**Comments on the Applicant's Without Prejudice Derogation
Case: Compensation Measures (REP8-005)**

**for the
Royal Society for the Protection of Birds**

**Application by Alternative Use Boston Projects Limited for an
Order Granting Development Consent for the
Boston Alternative Energy Facility**

Planning Inspectorate Ref: EN010095

**Figure 1-1 Cargo vessel numbers arriving at the Port of Boston between 1994 and 2020**

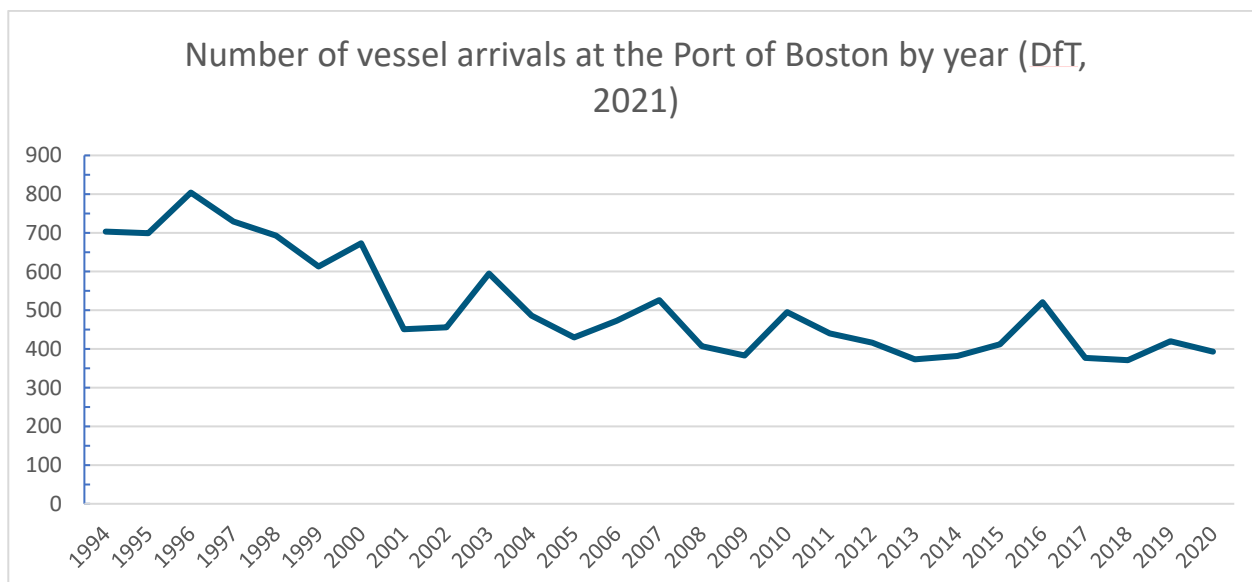
1.2.19	The proposed increase in cargo vessel numbers should be considered in the context of the number of current and historical vessel movements. This has varied considerably over the last 26 years between approximately 800 and 400 vessels per year, as shown in Figure 1-1 . The Port has been operational since before the SPA was designated, certainly back to 1918 when there were higher numbers of vessels (approximately 1000) visiting per year (Port of Boston, pers com.).	We have addressed this in earlier submissions (REP4-026). Any conclusions regarding the ability of The Haven to accommodate increased vessel movements must be based on the current ecological importance.
